Date:	20 October 2021	Contact name:	Steven Brown
Your reference:	Y/88/21/DOC	Telephone:	+ 44 (0) 203 857 8540
Our reference:	5877-AEA-ZZ-XX-CO-Z-0001	Email:	Steven.Brown@RHDHV.com
Classification:	Project related		
Enclosures:	Attenuation Calculations Updated drawing

The Green House Sussex Ltd, Lake Lane, Barnham, West Sussex, PO22 0AD.

Table 1: Arun LLFA Comments, and agreed resolution

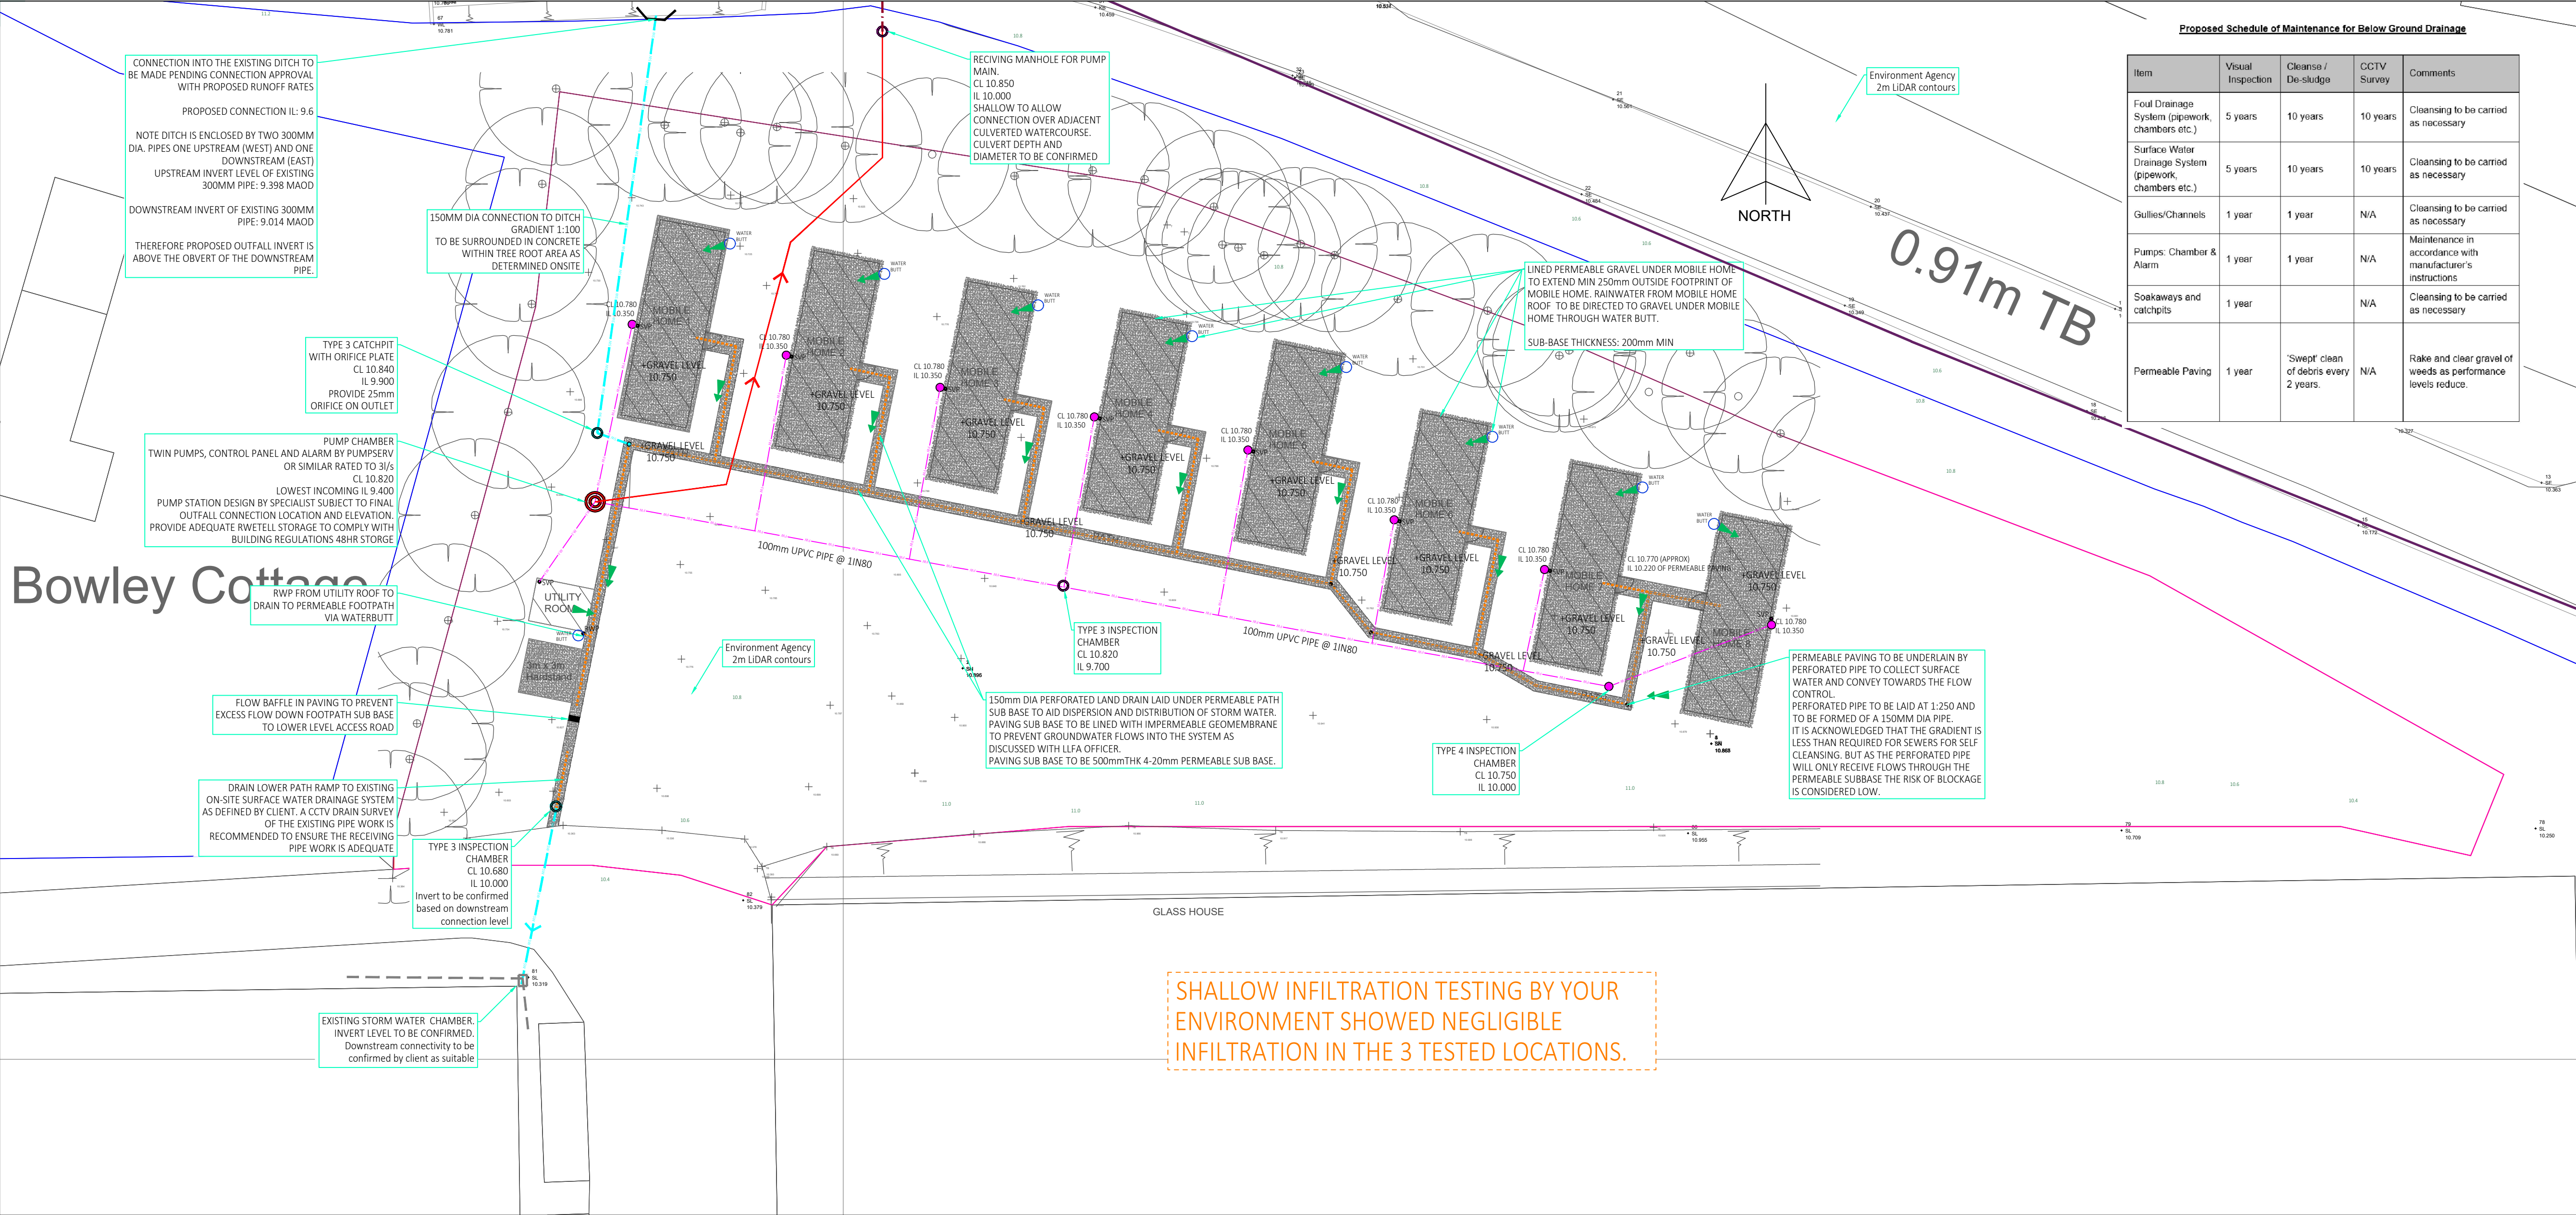
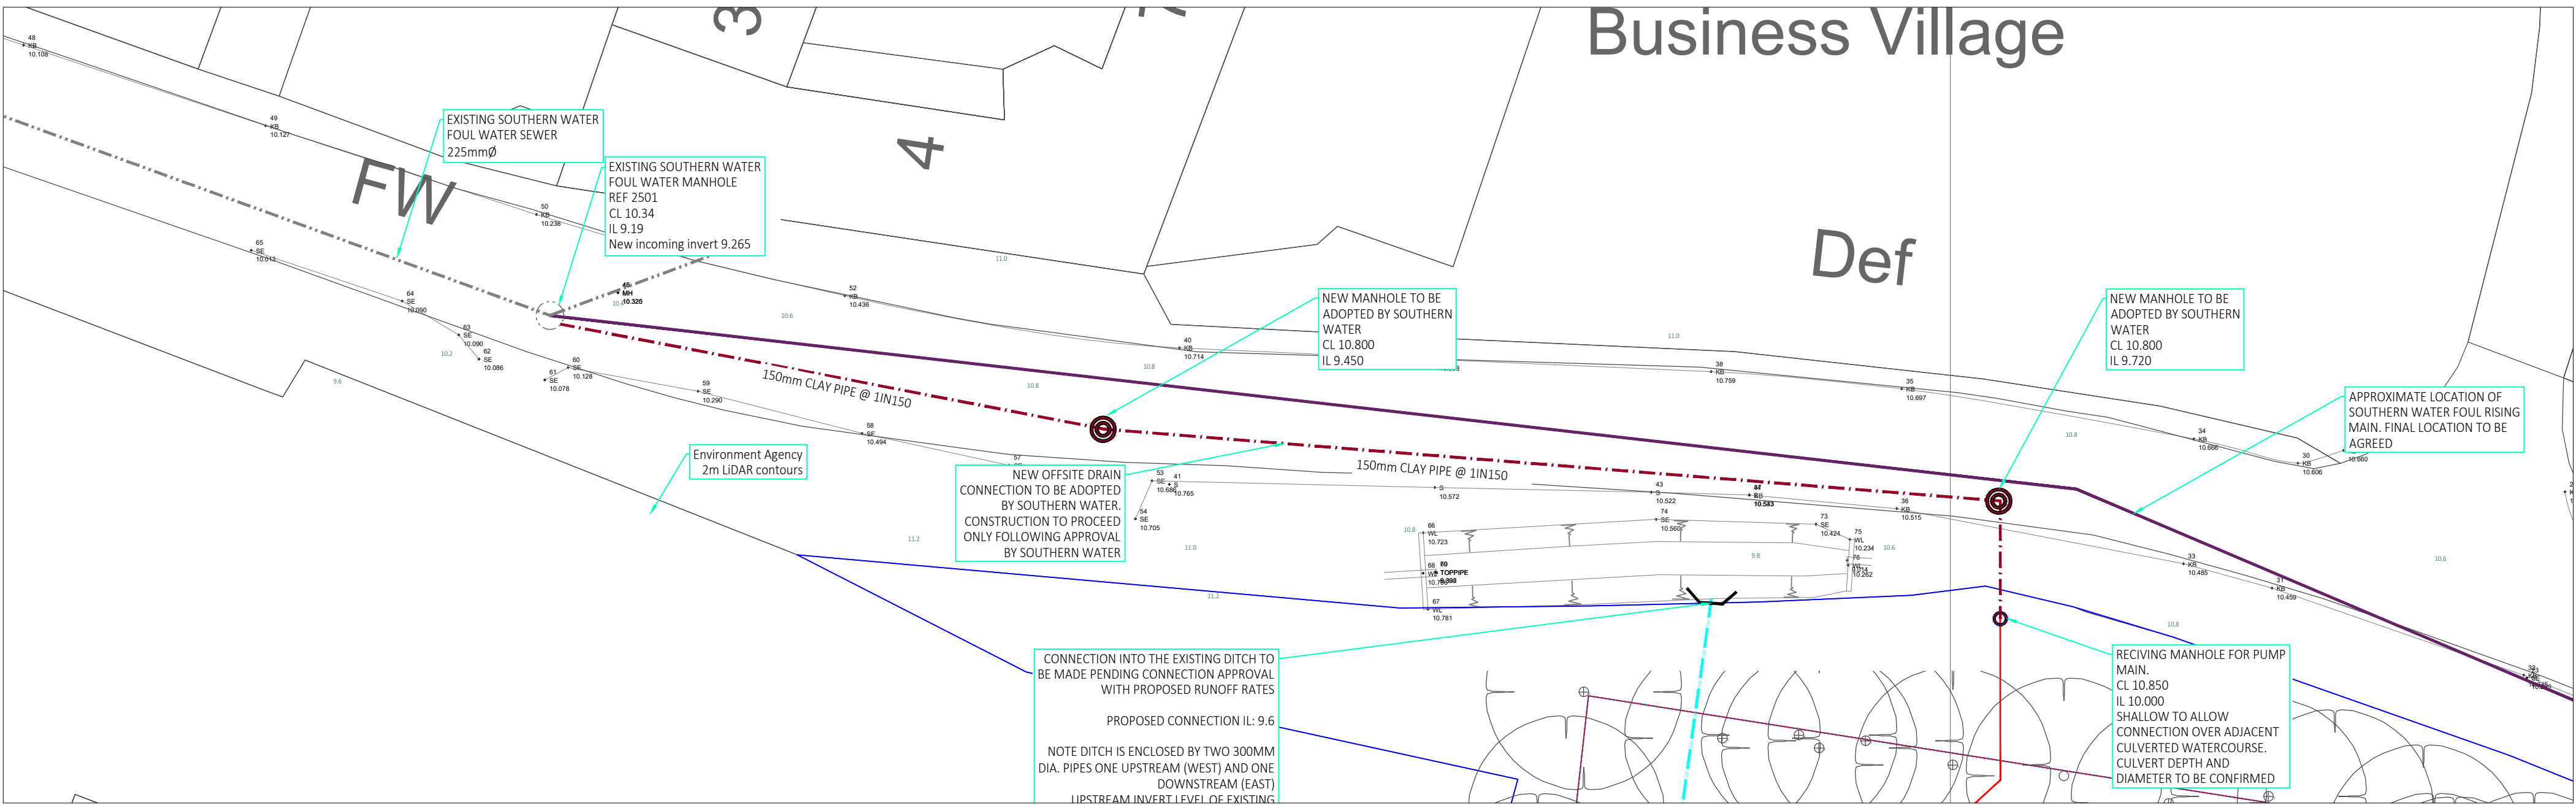
Arun LLFA Comment (05 October 2021, by Email)	Agreed Way Resolution
It appears that it is proposed to convey surface water through a granular sub-base. This is acceptable in principle, however a fall must be provided on the granular sub-base to promote conveyance. This fall should be reflected in calculations.	As it is proposed to include a perforated carrier pipe in/below the subbase it is not necessary to include a fall on the subbase. We will make it clearer on the layout drawing that it is proposed to have a perforated pipe, and this will include the pipe size and gradient.
A surcharged outfall should be modelled in calculations. With surcharged water levels equivalent to top of bank of watercourse.	To overcome the history of flooding that will result in a surcharge of an outfall, we will test the storage with a zero l/s outfall to simulate a flood locked outfall.
A 25mm orifice is proposed to control discharge rate from the site, this is quite small and could be prone to blockage. We query whether a hydro brake would achieve a similar flow restriction with a larger aperture?	The 25mm orifice is OK as it is downstream of permeable paving that will have a 20mm void which will mitigate the risk of blockage of the outfall

All surface water pipes must be labelled with diameter and fall.	A clear note will be included that all pipes will be 150mm Dia. and laid at a gradient of 1:100.
The true bed level at the point of connection to the watercourse must be provided, along with soft bed level.	It is proposed to construct the outfall above the obvert of the outgoing pipe from the ditch this should be above the 150mm clearance above the bed that Arun usually require
A concrete bed and surround will be provided where the pipes go through the trees.	This will be indicated on the drawing.
Site specific construction details of the flow control device and outfall must be provided.	The construction details for the flow control device and outfall will be updated to include the site specific cover and invert levels.
